Ponderosa at Lorson Ranch Filing No. 3
Transportation Memorandum
(LSC #194890)
November 15, 2019

RE: Ponderosa at Lorson Ranch
El Paso County, Colorado
Transportation Memorandum
LSC #194890

A LANDSCAPE PLAN FOR PONDROSA AT LORSON RANCH FILING 3

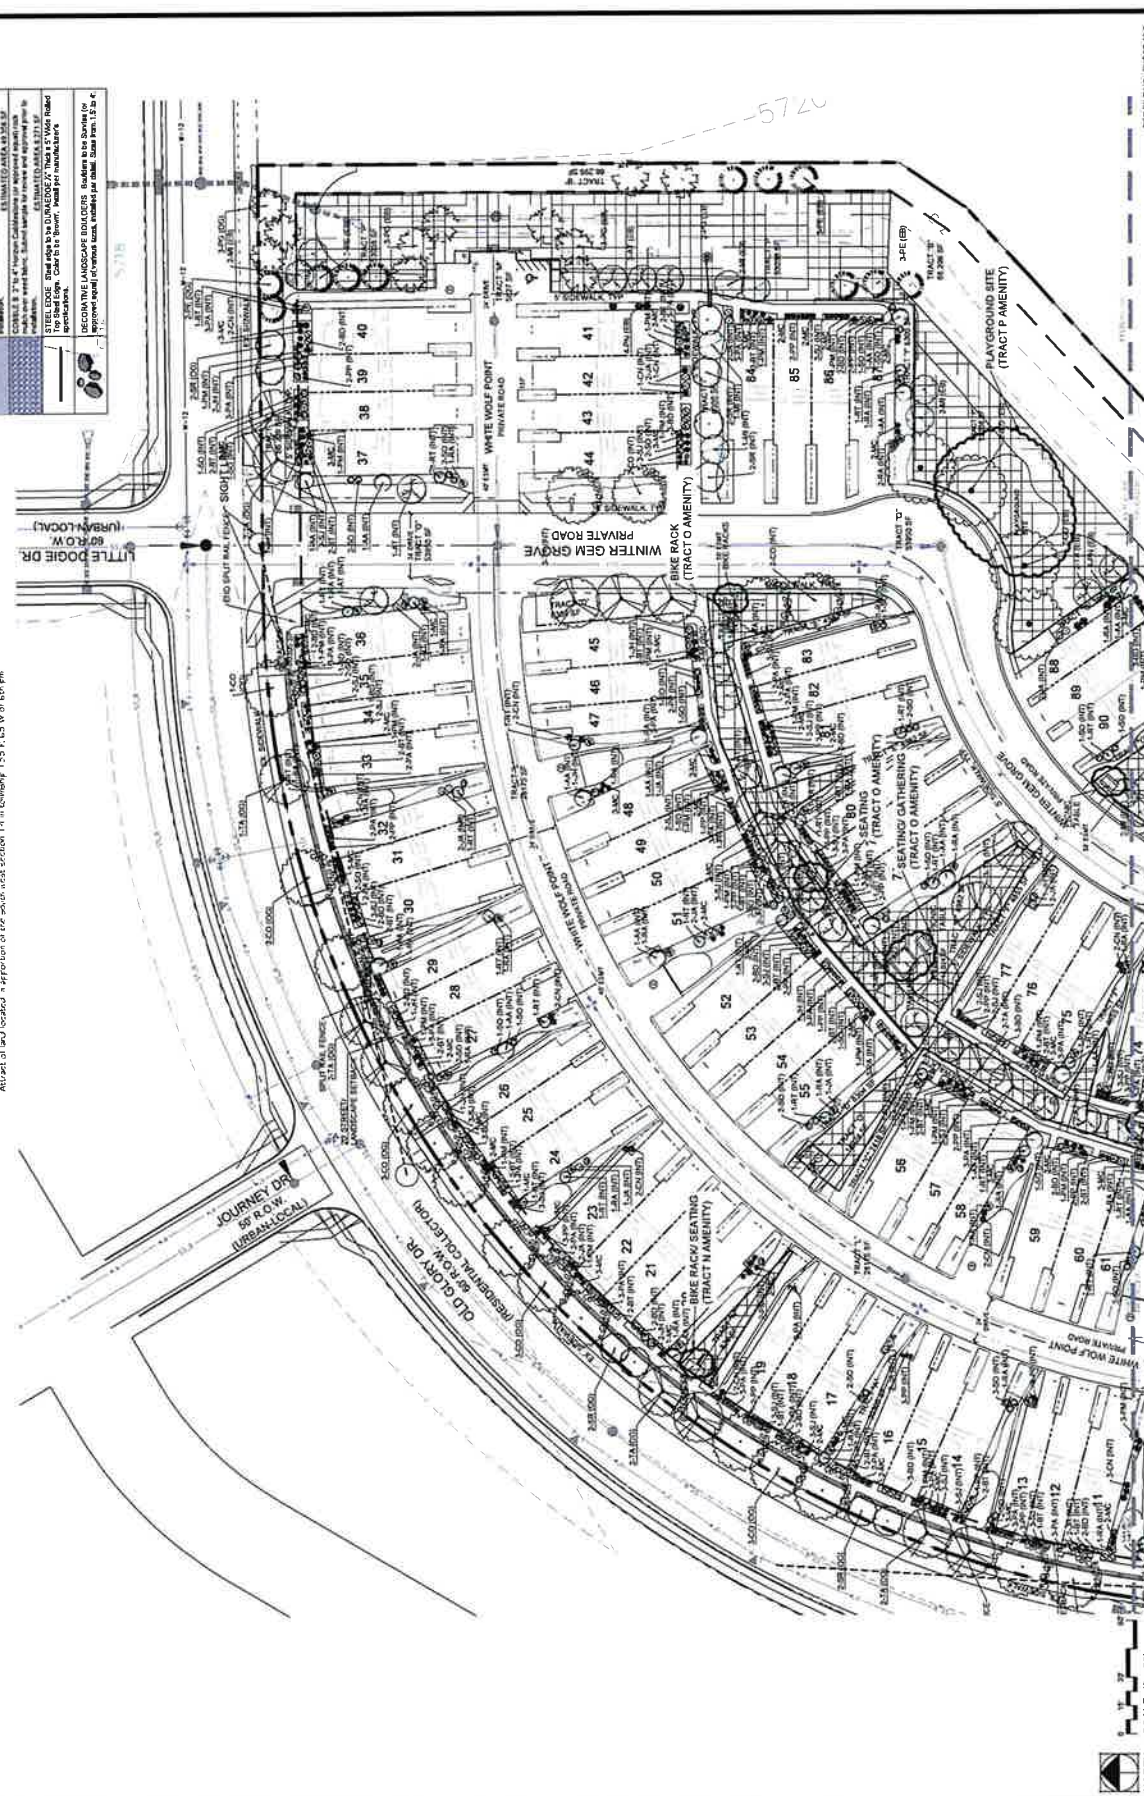
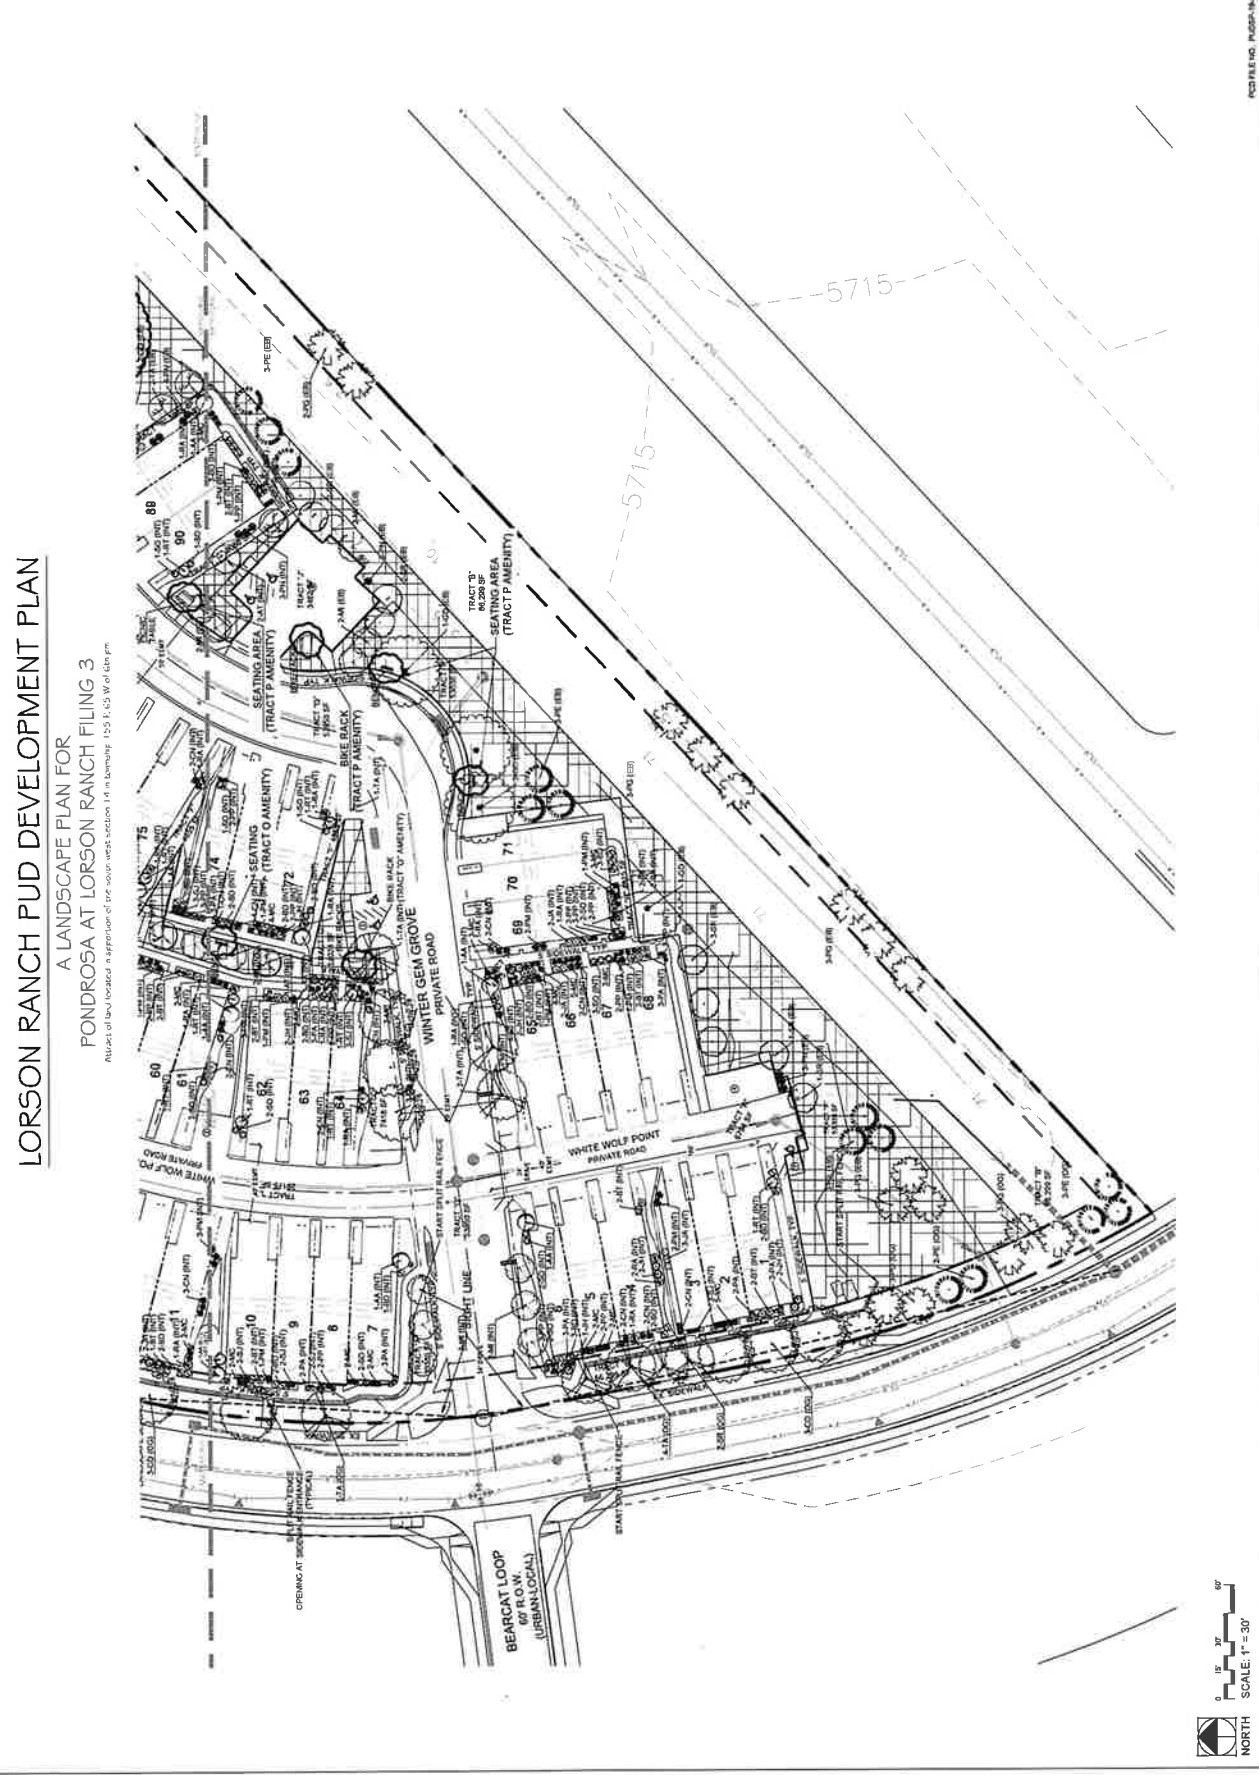
What distances are provided? Discuss proposed landscaping, including plant species, and if the landscaping plan needs to be revised.
